Our Ref: WA/44/19/PL
Your Ref:

Town & Country Planning Act 1990 (as amended)
Town and Country Planning (Development Management Procedure) (England) Order 2015
Application for Planning Permission

Development Temporary permission (maximum 12 months) for a single storey timber framed WC & lobby extension. This application affects the character & appearance of the Walberton Village Conservation Area.

Location Walberton Baptist Church The Street Walberton

SIDE ELEVATION

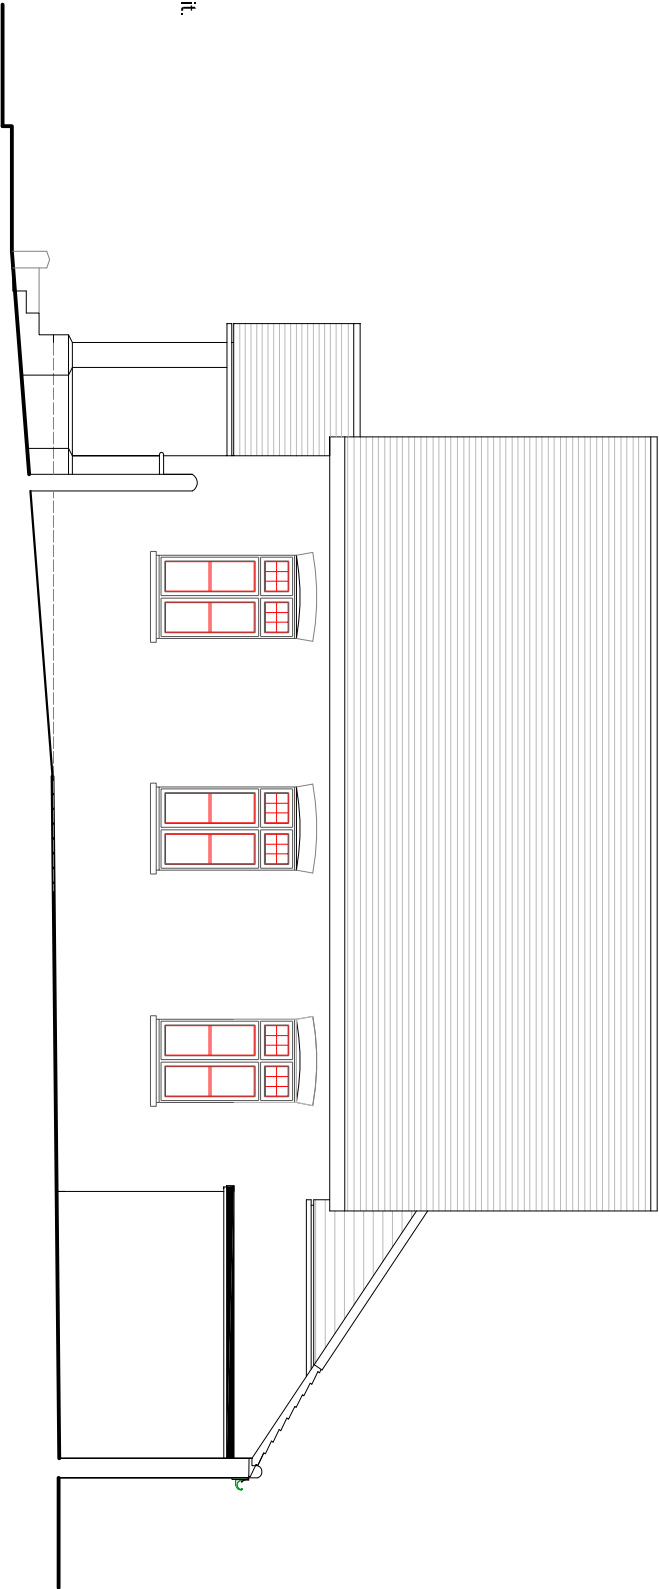
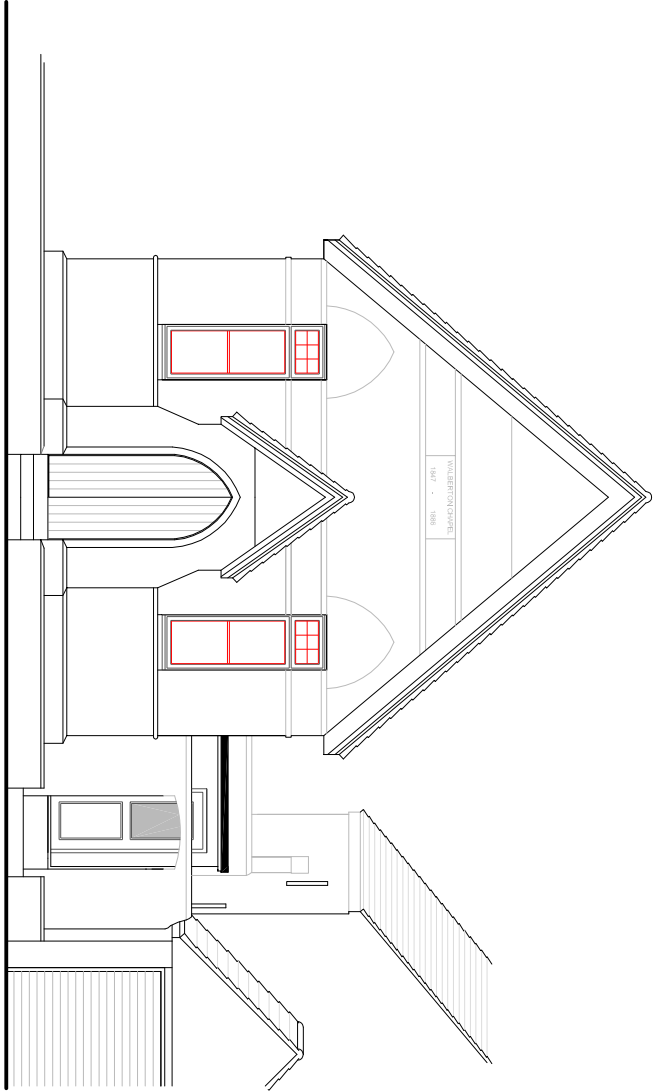
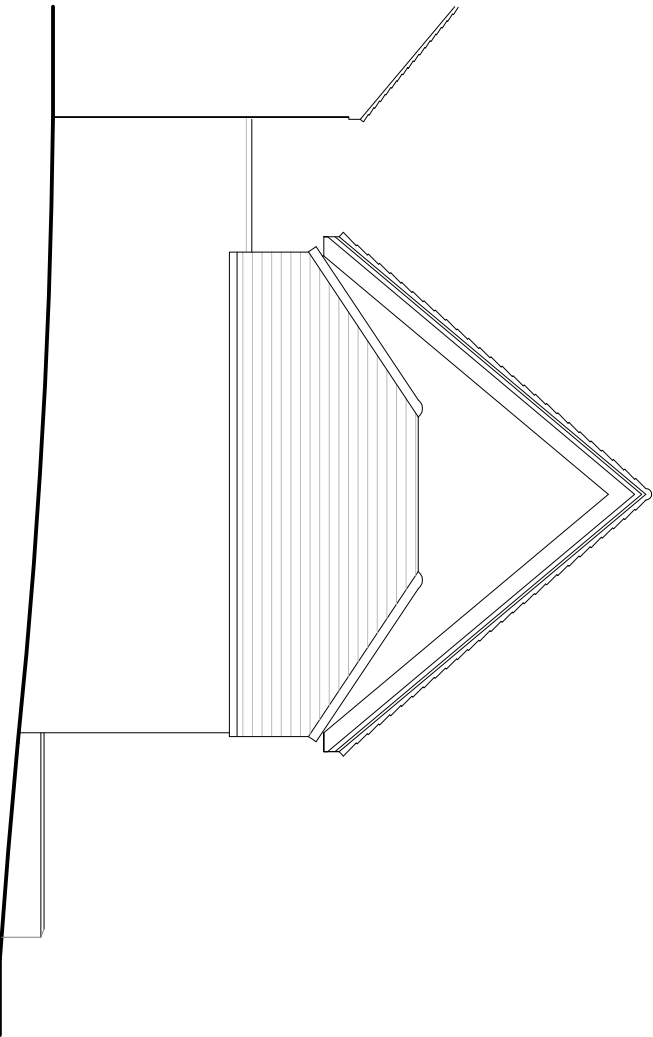
The proposed floor plan and side elevation do not accord. Please amend accordingly.
